From: Amanda Scholes on behalf of Planning.Responses
Sent: 19 May 2017 09:00
To: Planning Scanning
Subject: FW: FW: Y/13/17/DOC 38 Cherry Avenue, Yapton

Please upload as further drainage engineer comments.

PROJECT No MC/029	DWG No 2	REV No B
SCALE 1:50/1:100 @ A1	DRAWN MEC	CHK'D CLIENT

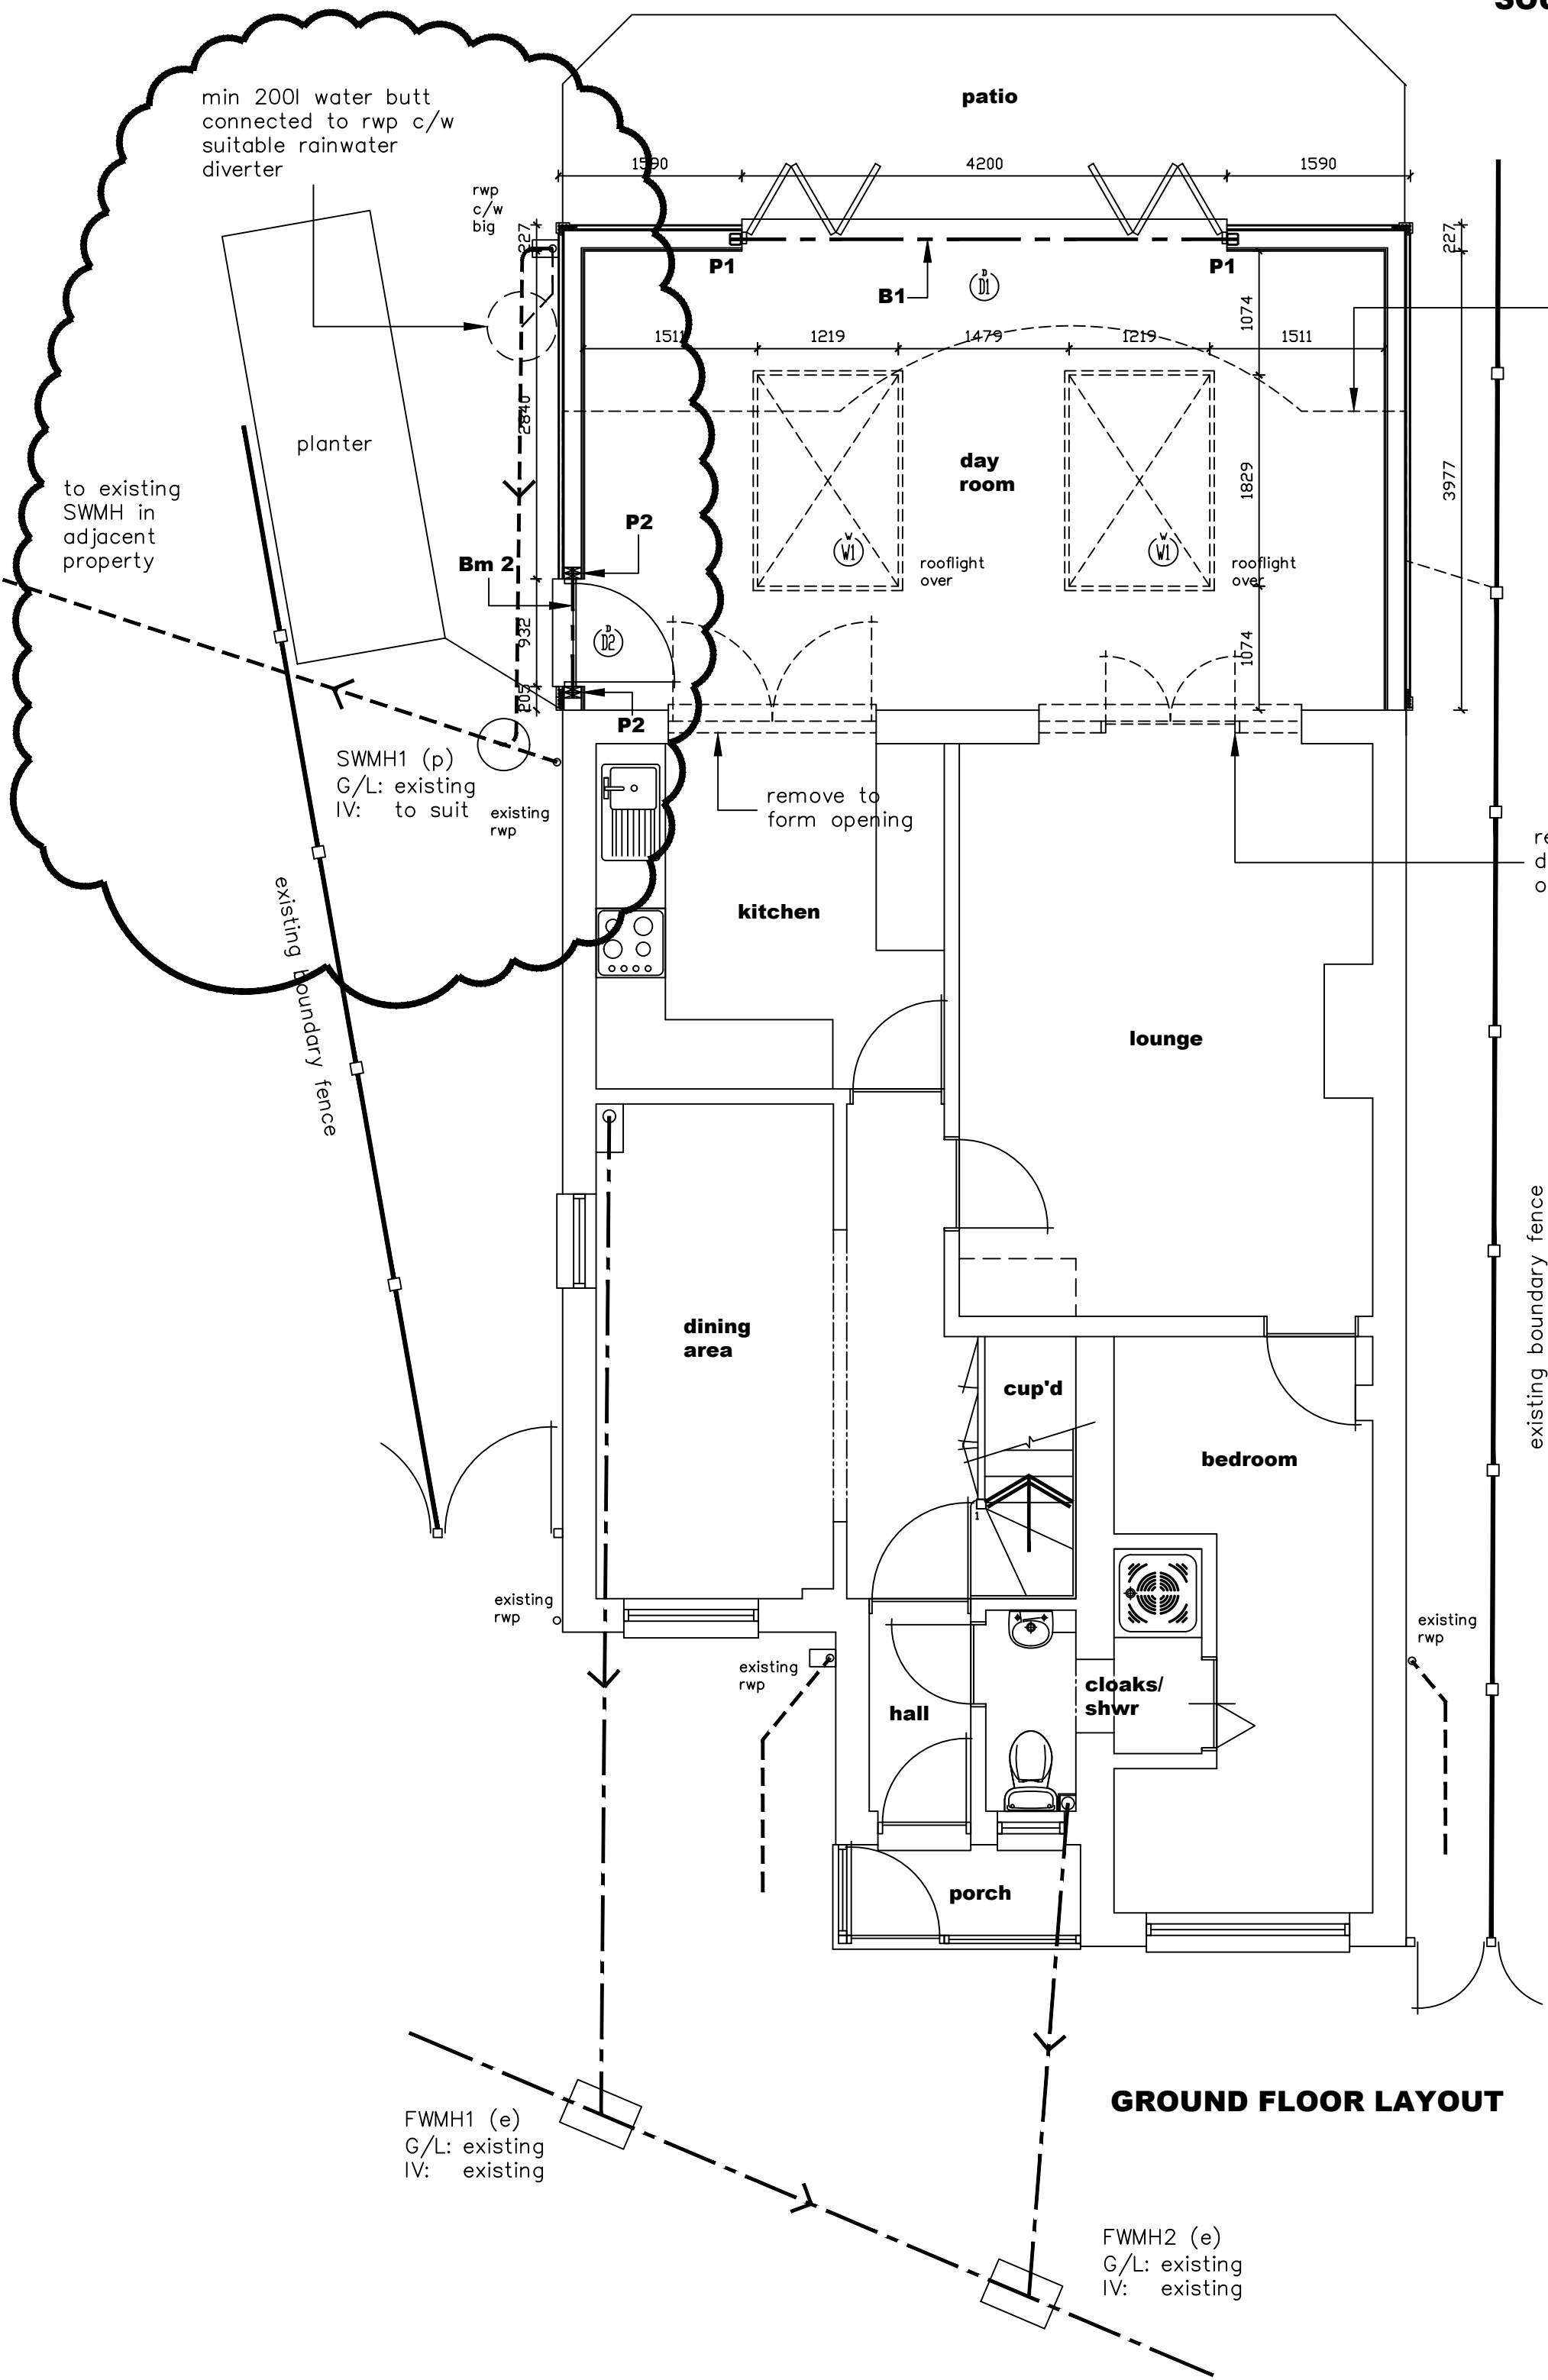
Having reviewed the CCTV survey, it is apparent that the existing pipe appears in good condition but is only 100mm diameter. On that basis, the connection from the new extension is acceptable provided that a new manhole (construction details required) is constructed where the new rainwater pipe will connect to the existing pipe.

Also, a minimum 200 litre water butt is to be connected to the new rainwater downpipe via a water diverter/overflow. See enclosed picture of the diverter/overflow arrangement. The water butt will help store water at times when the water butt is empty/partially empty, and when full will overflow back into the piped system.

Please could the applicant provided a revised plan indicating these requirements, so that it can be considered further.

I can now confirm that the revised proposals are acceptable and the condition can be discharged.

As promised, please find attached the updated layouts which show the as existing SW system into the adjoining property as per the findings of the CCTV survey. I have also amended the proposed layouts to take on board the recommendations of your Drainage Engineer.. Hopefully this will satisfy his requirements and enable the condition remaining on this project to be approved.
